Rampion 2 Offshore Wind Farm – EN010117

Section 51 advice regarding draft application documents submitted by Rampion Extension Development Limited

On 21 April 2023 Rampion Extension Development Limited submitted the following draft documents for review by the Planning Inspectorate as part of its Pre-application Service¹:

Drawing Title:
**SPECIAL CATEGORY LAND PLANS
REGULATION 5(2)(i)(iv) OF THE INFRASTRUCTURE
PLANNING (APPLICATIONS: PRESCRIBED
FORMS AND PROCEDURE) REGULATIONS 2009
KEY PLAN**

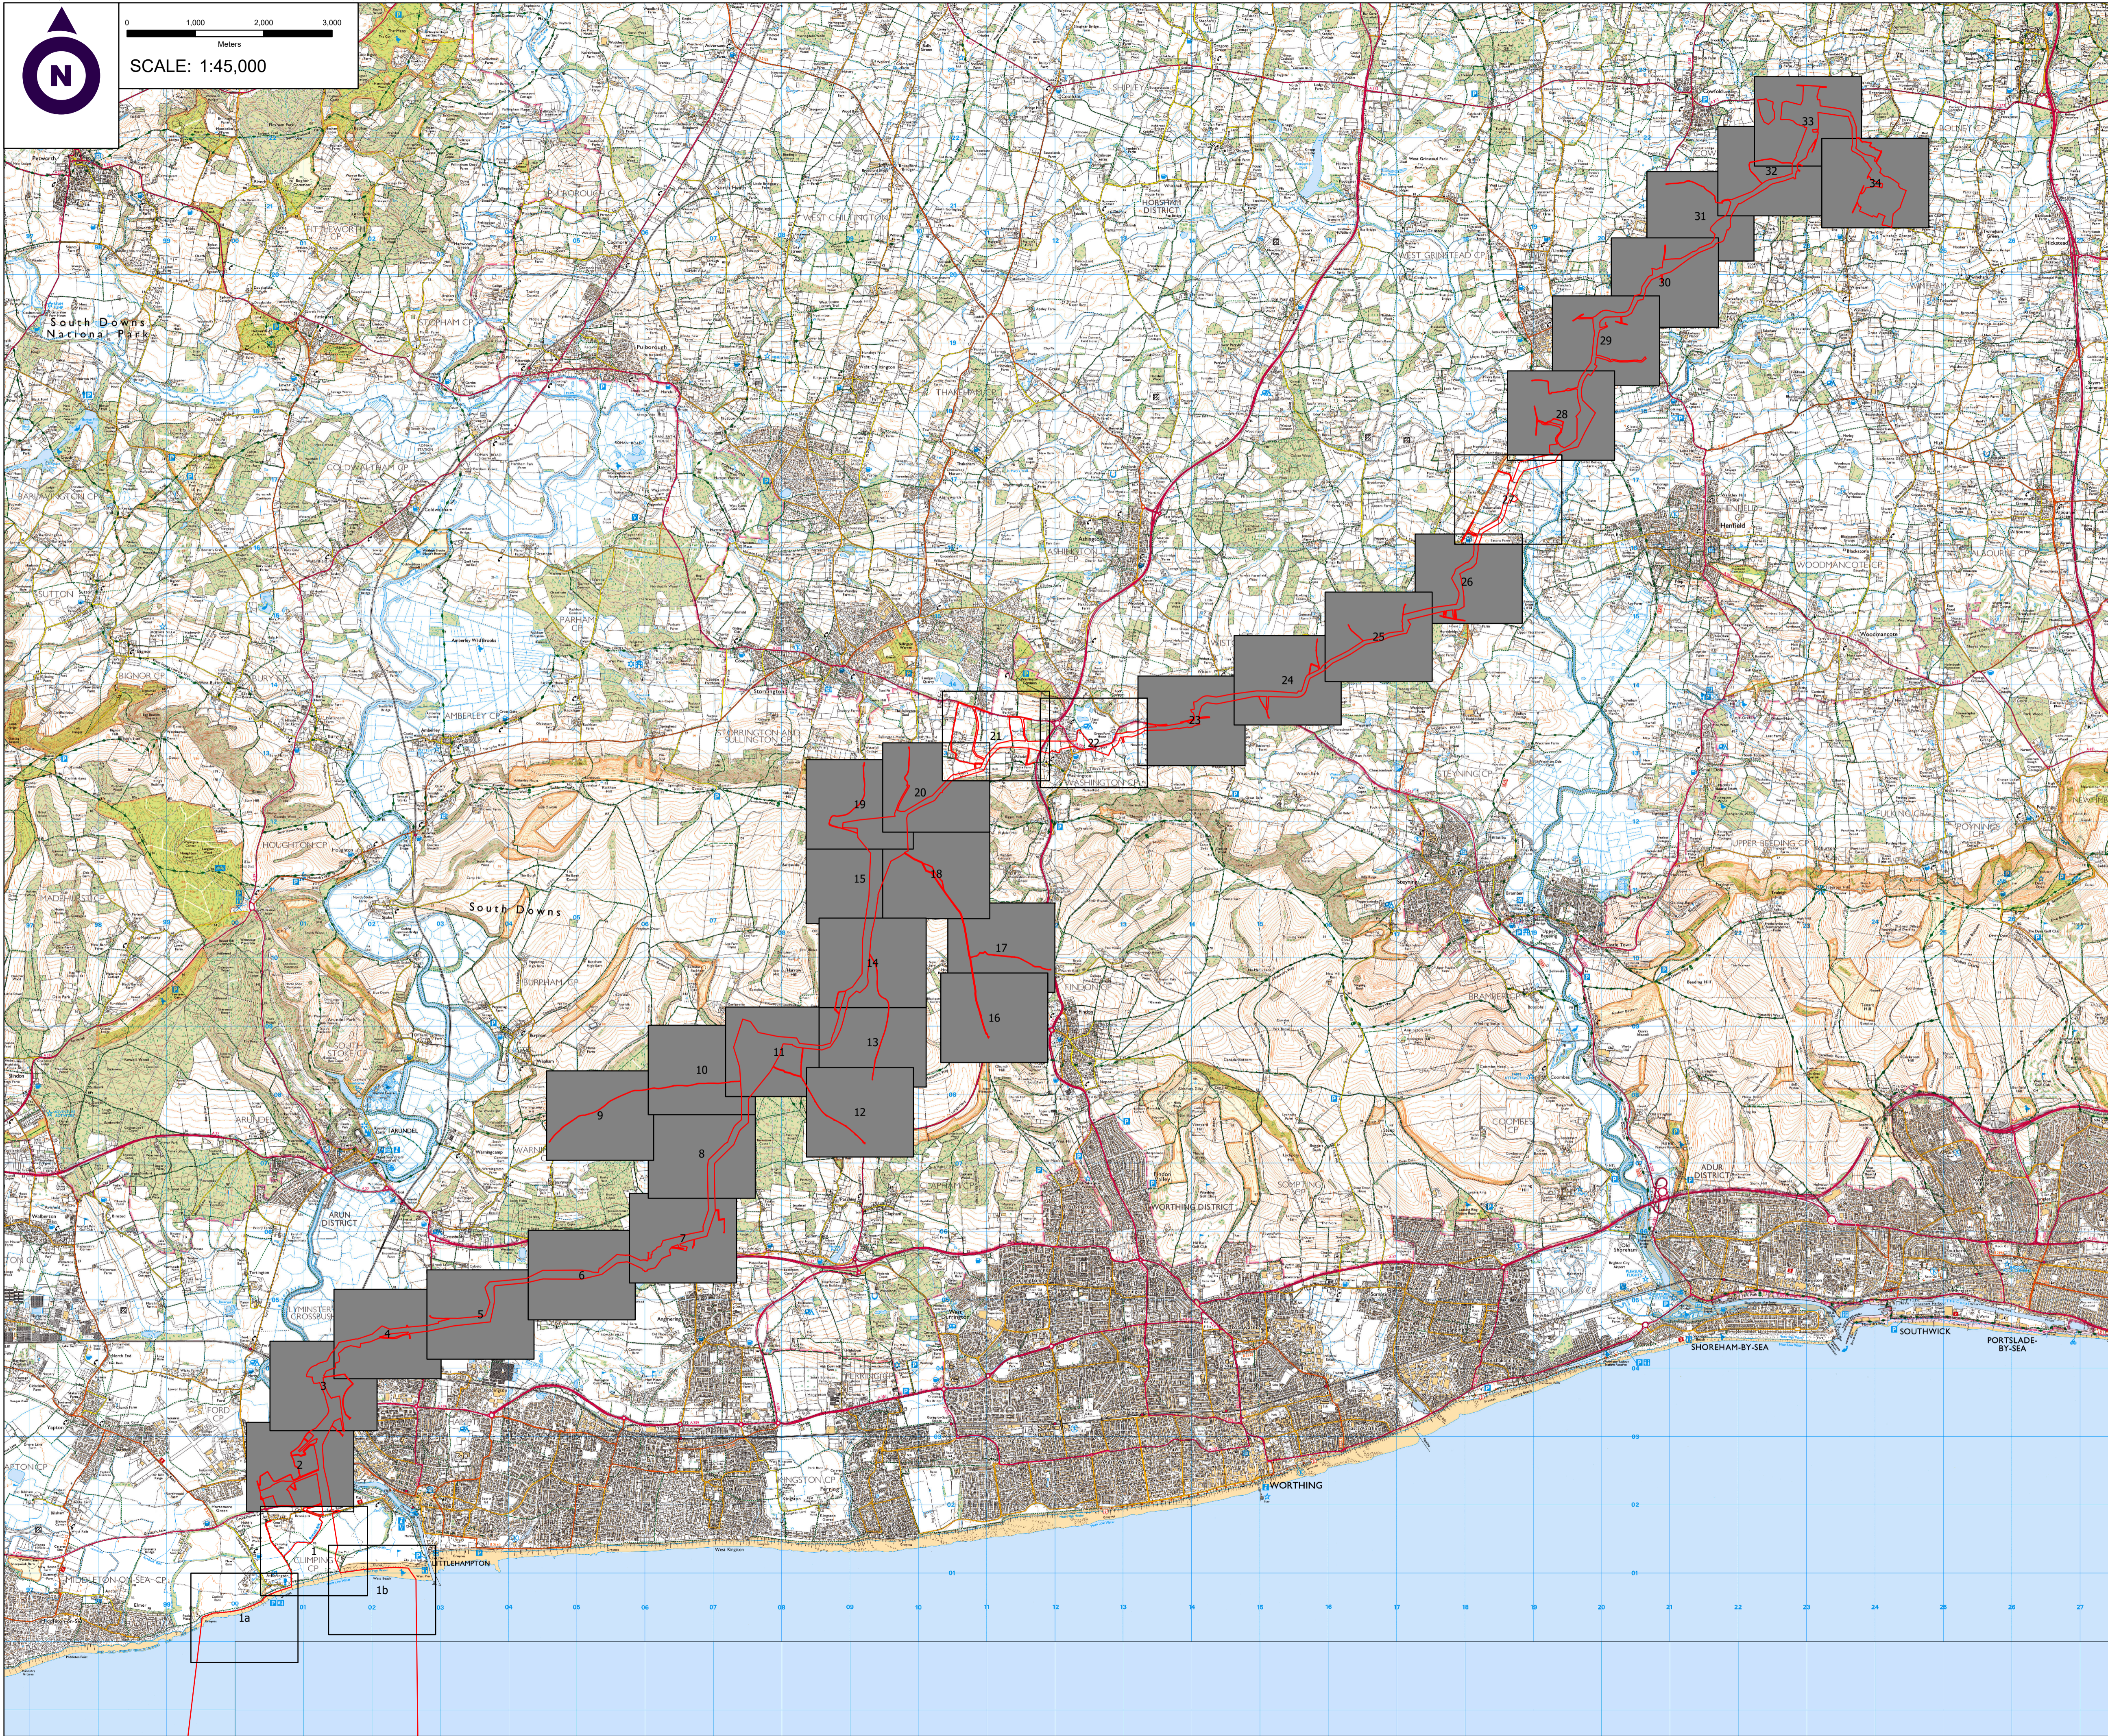
10. Special Category Land Plan		
Ref No.	Plan ref	Comment/Question
	General	Both plans are currently using a similar colour and hatching pattern (blue with horizontal lines). Could be an issue if these plans are put into 1 document together as it will be difficult to distinguish between them. (Also mentioned in Crown Land Plans). Appears to be missing locations.
	1/015	Appears to be missing locations.

10. Special Category Land Plan		
Ref No.	Plan ref	Comment/Question
	1/020	Please note only 1 Special Category Land Plan shared but information for 2 Plan sheets have been given in the BoR, therefore only 1 sheet has been checked.
